From: Anita Gardner
Sent: 23 May 2017 14:15
To: Planning.Responses
Subject: FW: Proposed Development at East St/Fitzalan Rd, Littlehampton: Planning Ref. LU/127/17/DOC

Proposed Development at East St/Fitzalan Rd, Littlehampton
Planning Ref. LU/127/17/DOC
Planning Application Ref. LU/173/16/PL

We have recently received a copy of your e-mail dated 16 May 2017, as issued to Anita Gardner – Principal Planner, Arun District Council (included below) and note that you have raised some issues relating to our Geotechnical Assessment Report No. CCL02814.CD70, dated May 2017. We clarify these matters below.

SOAKAWAY CONSTRAINTS PLAN

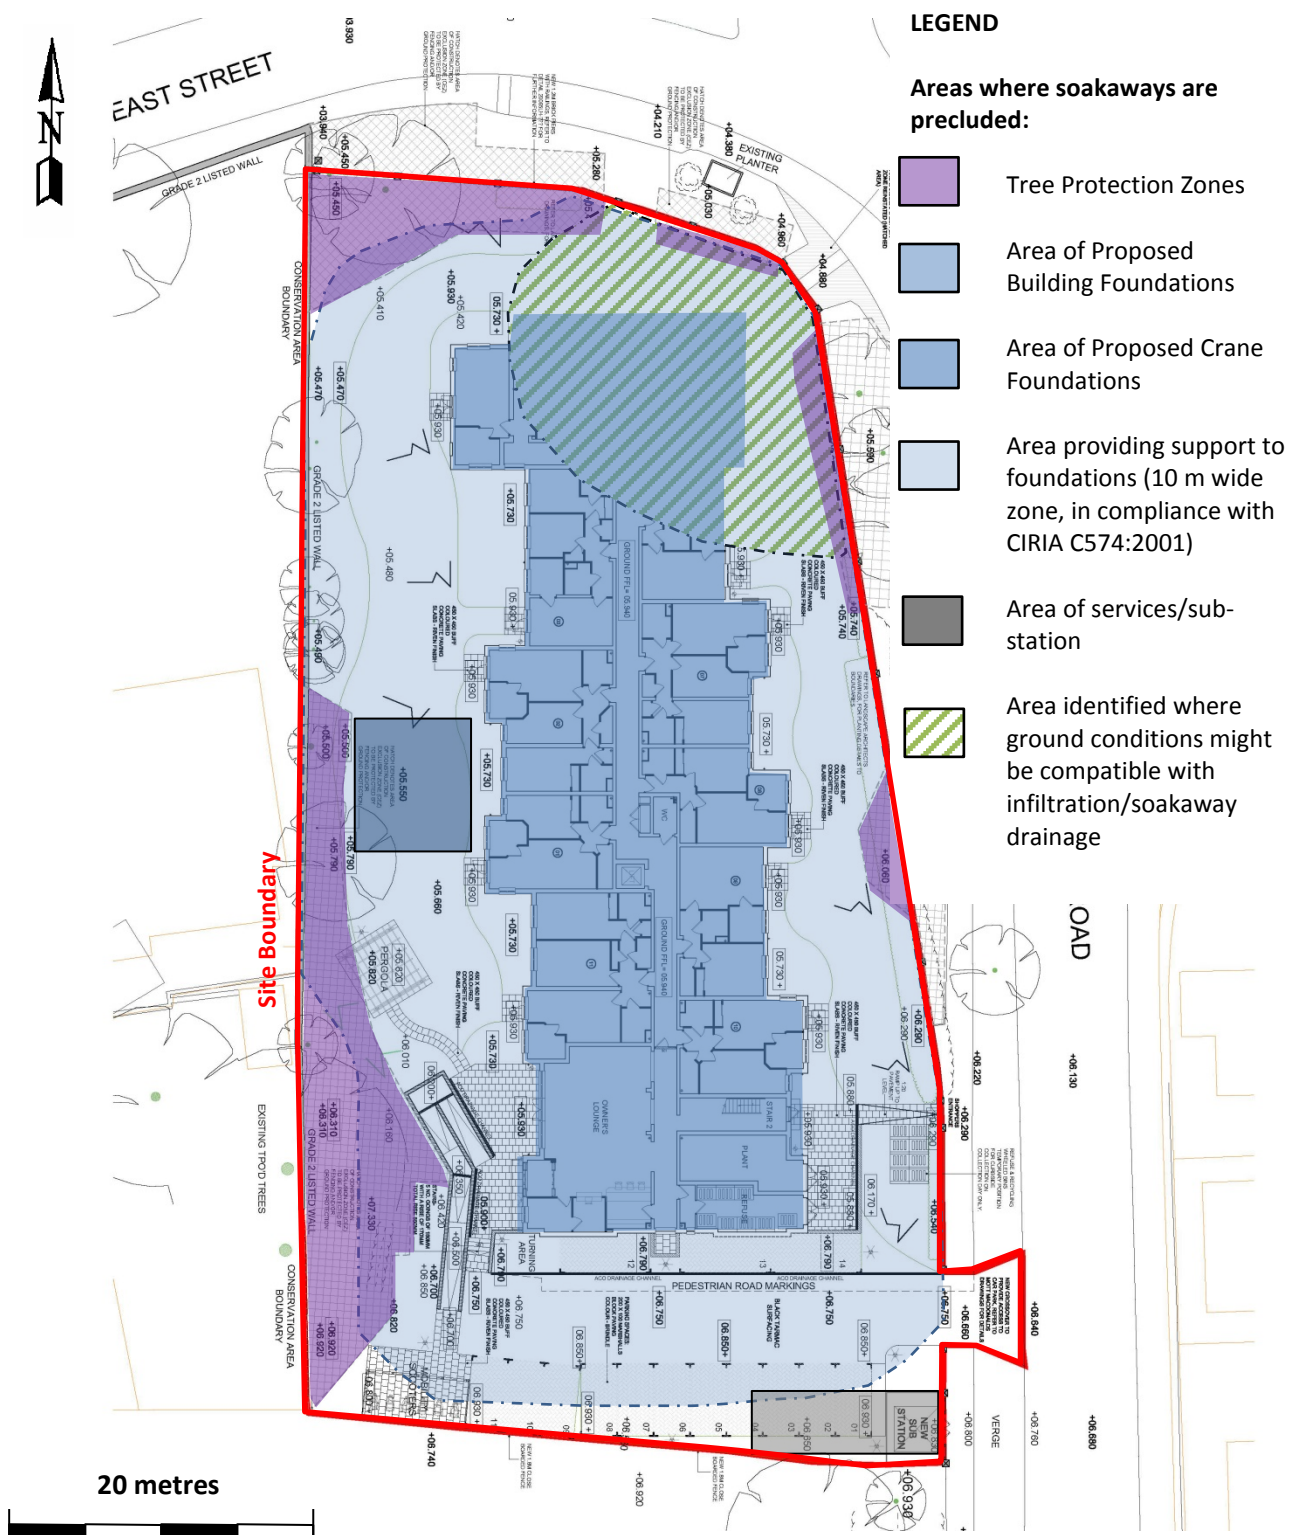
From reading their geotechnical report, it appears that they have undertaken two percolation tests, one in TP1 and one TP2. It is noted that these have not been undertaken in the winter period and have only had one test done in each trial hole (as opposed to three in each). The results in TP1 are ok, whilst those in TP2 are not. The better result was achieved in the trial hole that penetrated the chalk layer (as you would expect).

At this stage, and with the information provided, it is not possible to dismiss the use of soakaways, and therefore I would suggest that more investigations are carried out with the excavation of further trial holes (at the location of potential soakaways and sufficiently penetrating the chalk layer), and further percolation tests undertaken, in the winter period.

Below the superficial deposits, highly weathered chalk strata are present. The depth to the chalk strata varies widely across the site, from 1.8 m to depths in excess of 5 m. Such variations occur over short distances, and it is evident that chalk is present at shallow depth only in very restricted areas (which are located below the proposed building).

At 4 of the 6 locations where chalk has been recorded, the chalk comprises clayey Grade Dm strata, water infiltration along fissures/joints is precluded in such structureless chalk. As outlined in CIRIA C574:2002, permeability values in such material is generally less than 1×10^{-7} m/s, and soakaway drainage is impracticable in such strata.

It is noted that Grade Dc chalk has been observed at (only) 2 isolated locations within the site, and which included the infiltration test in trial pit TP1, where an infiltration rate of 3×10^{-6} m/s is recorded. Unfortunately, both of these locations are below the area of the proposed building, such that soakaway drainage is precluded at these positions.

Even if the development were to be reconfigured, it is noted that the areas of the site are very small where more permeable Grade Dc chalk has been identified, such that it is impracticable to provide the required size of soakaway drainage systems within such strata.
